RE: Daily Field Report for 06/05/2025
Lot 552 Creekside Oaks North (CMT) Lillington, NC
Building & Earth Project No : RD250525

Project Name:	Lot 552 Creekside Oaks North (CMT) Lillington, NC	Project Number:	RD250525
Client Name:	Dream Finders Homes-Carolinas	Placement#:	FO-1
Contractor:	Dream Finders Homes-Carolinas	Technician:	Hernan Perdomo
Monitoring:	DCP

S-1.2a
MONO SLAB
FOUNDATION PLAN

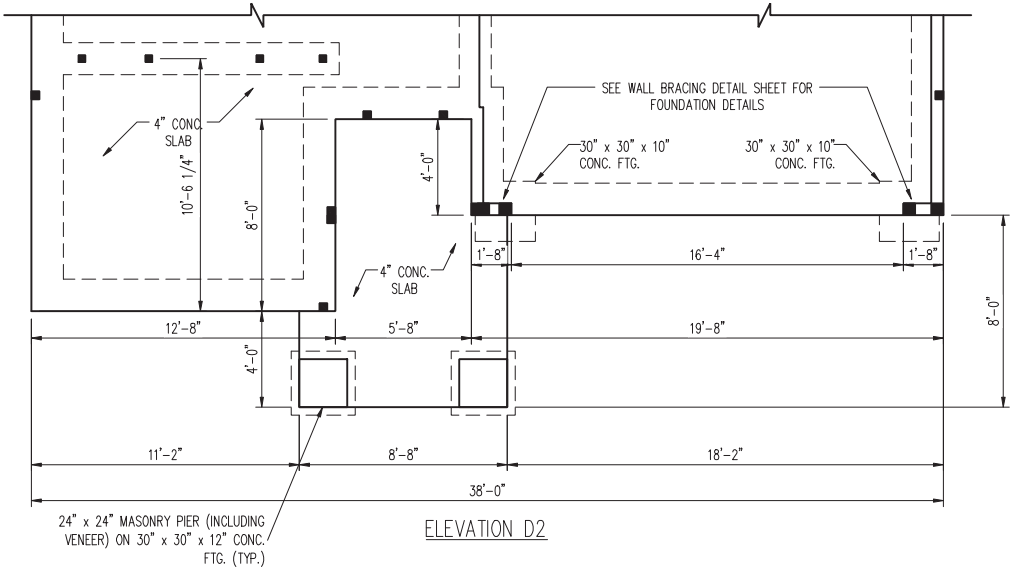
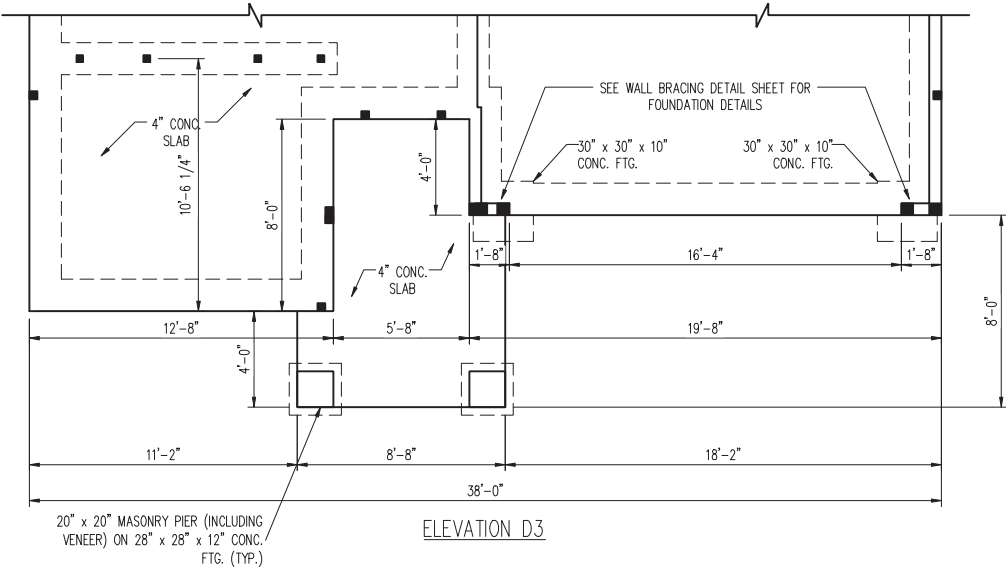
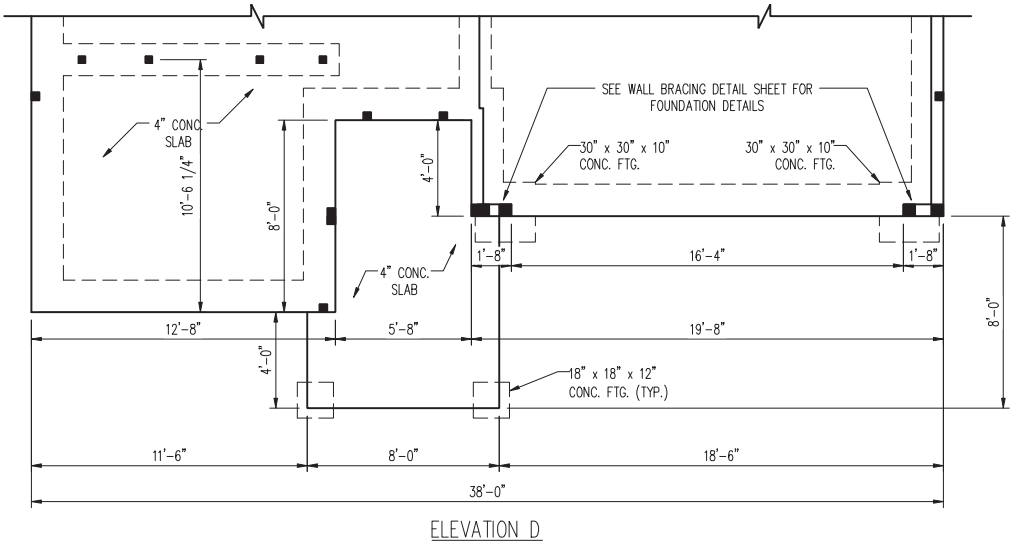
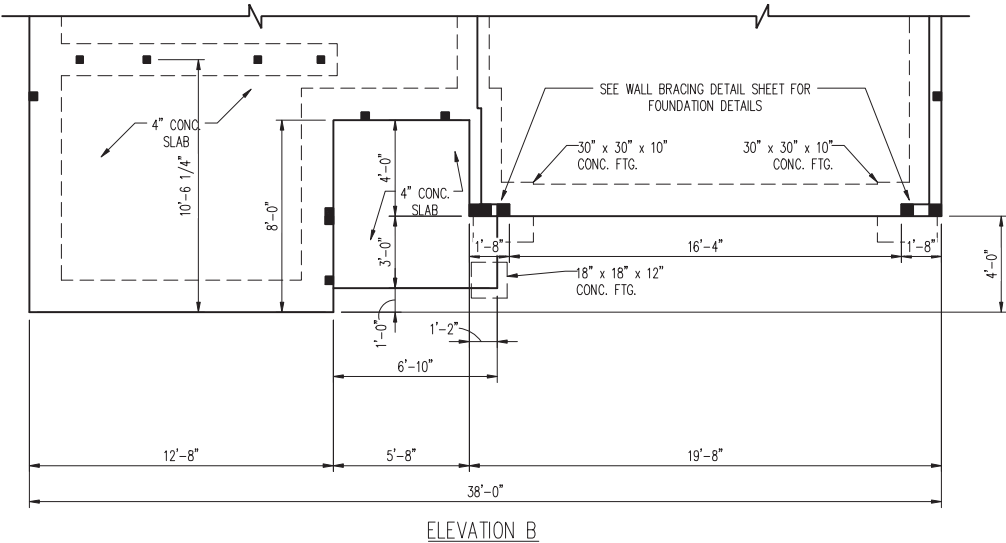
Comment 1 : Based on our observations and test results, the newly placed fill/existing soils appear to be disturbed we recommend to reroll the surface soil before the placement of the slab.

Based on our observations and test results, the newly placed fill/existing soils appear to be disturbed we recommend to reroll the surface soil before the placement of the slab.
